App No: BE/40/18/PL

Address: Land West of New Barn Lane Bersted

Proposal: New access from New Barn Lane to Land West of New Barn Lane
& relocation of 5 No. existing parking spaces.

Liz Rogers
Environment Officer
Environment
Chichester District Council

Proposed Access to New Barn Lane

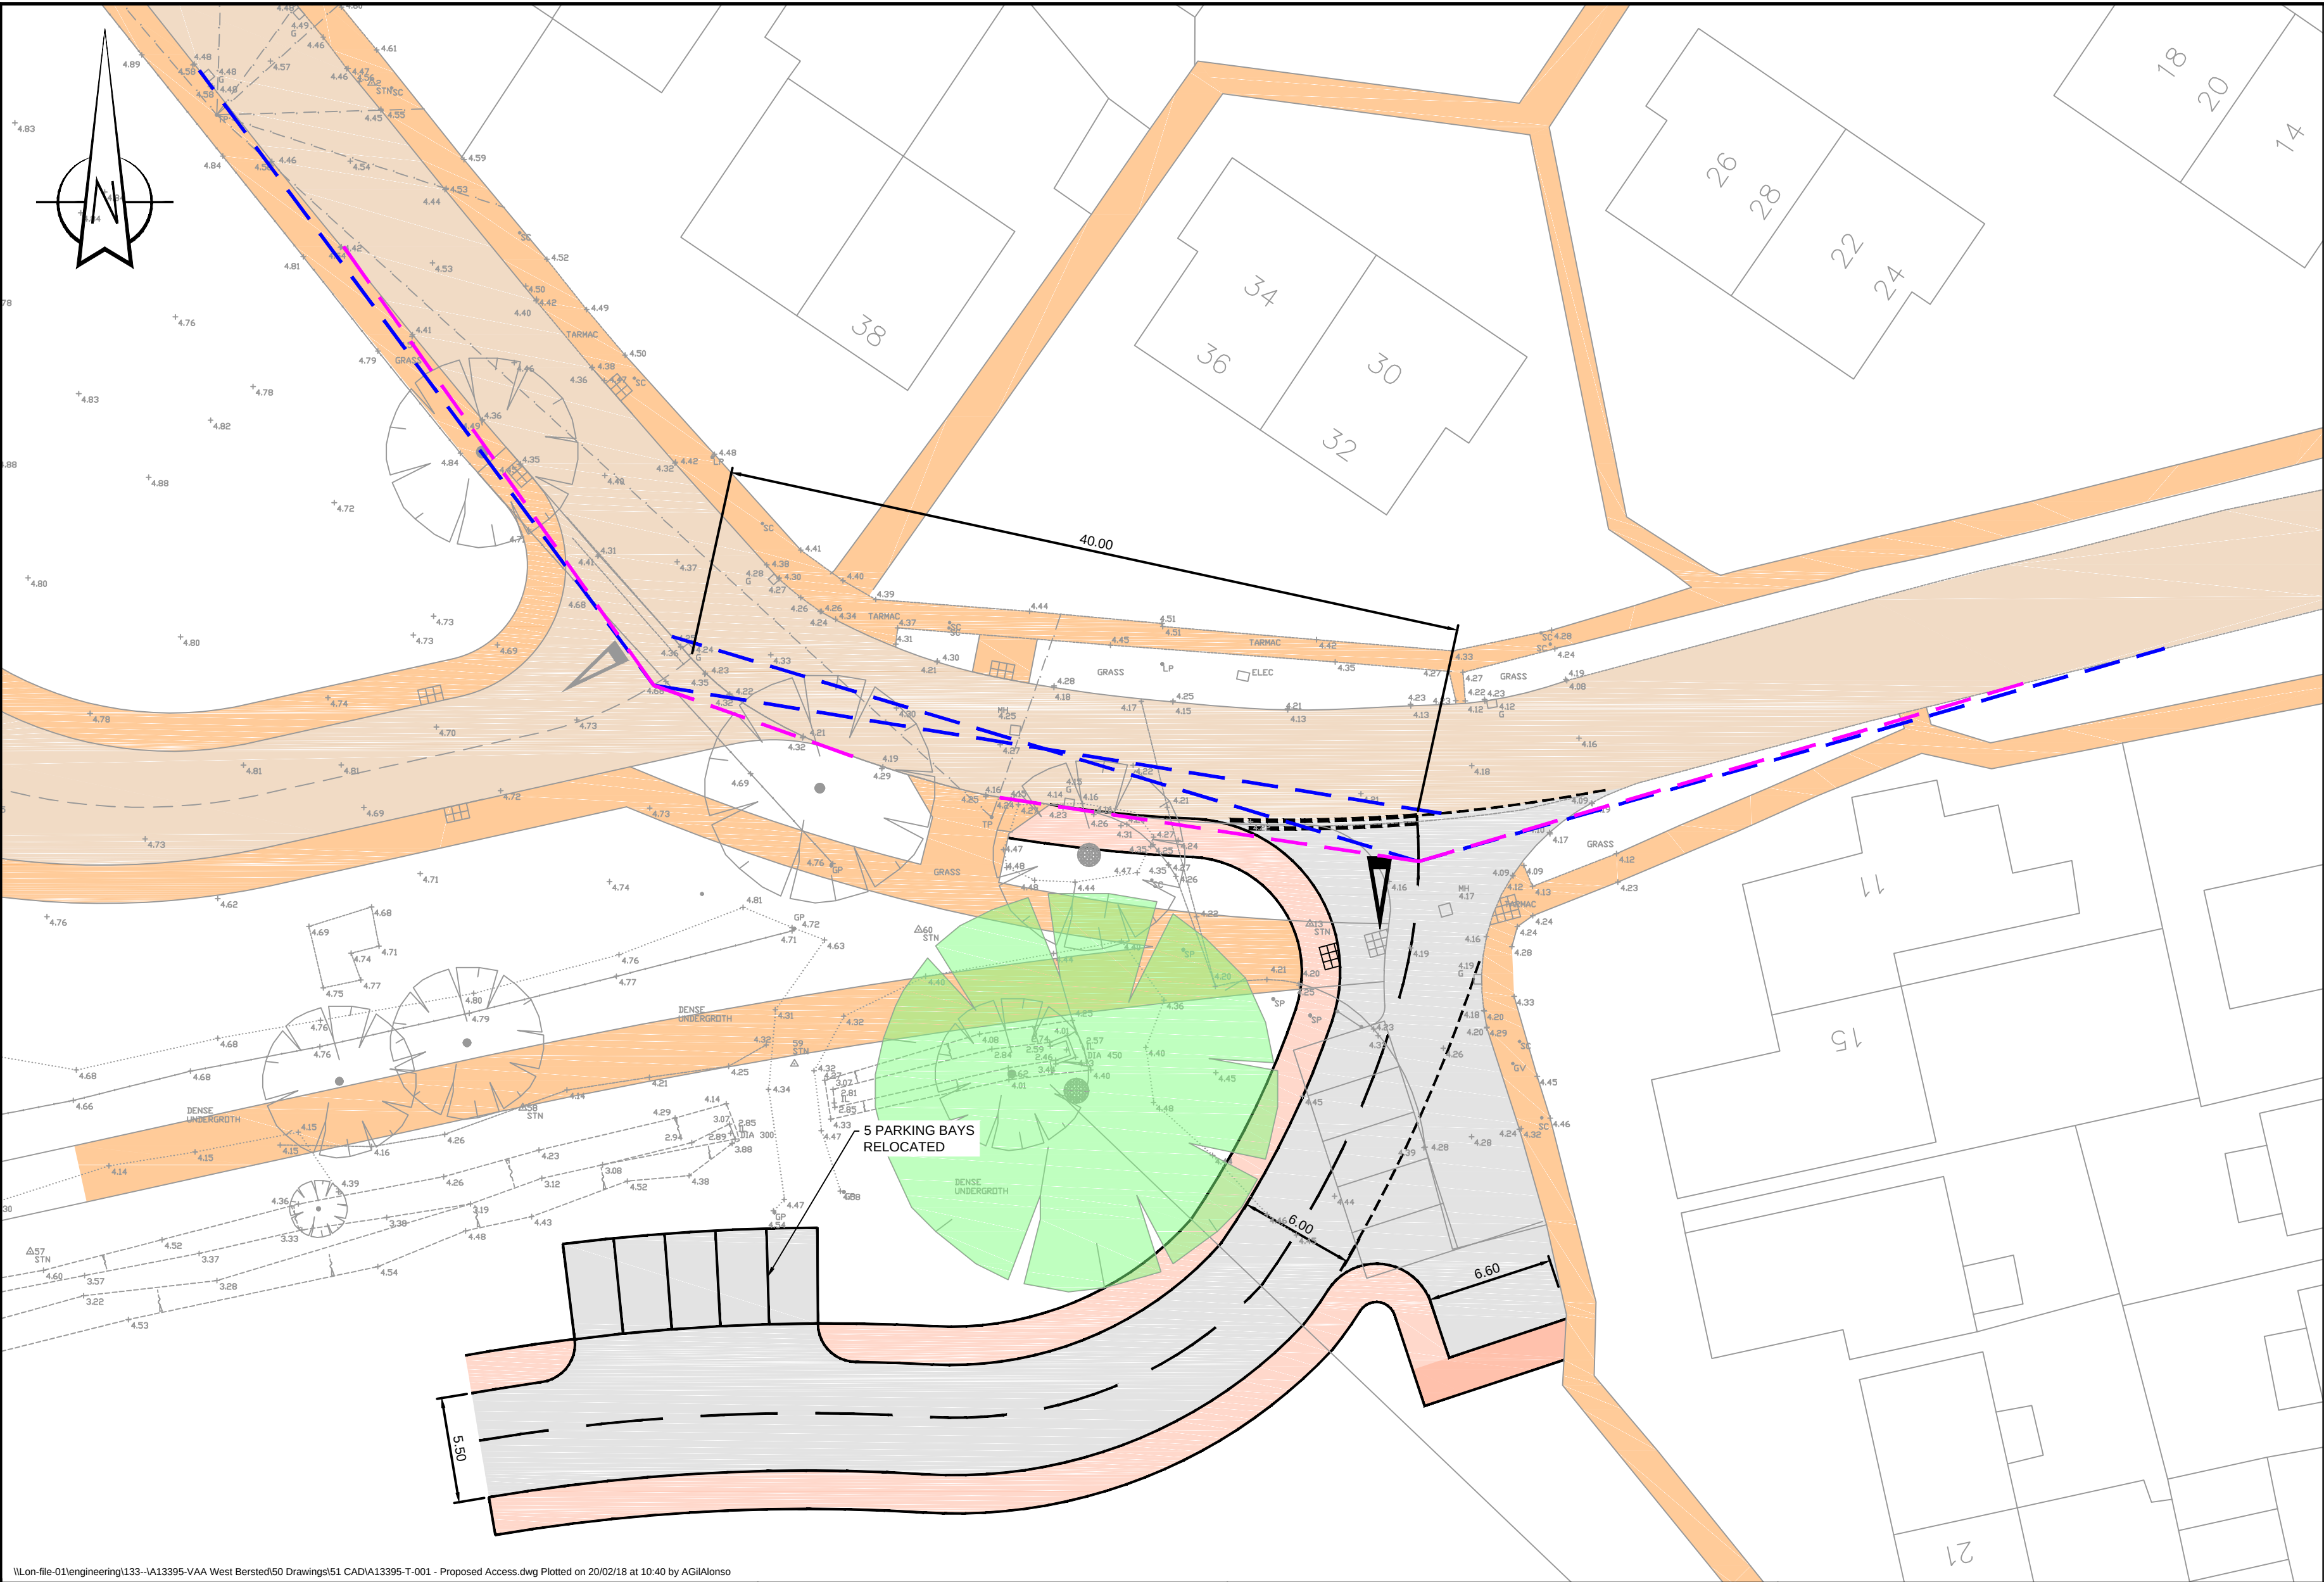
Please can the applicant confirm whether any hedgerow will need to be removed to facilitate the access to the site? If hedgerow does need to be removed / altered then further surveys for dormice would be required.
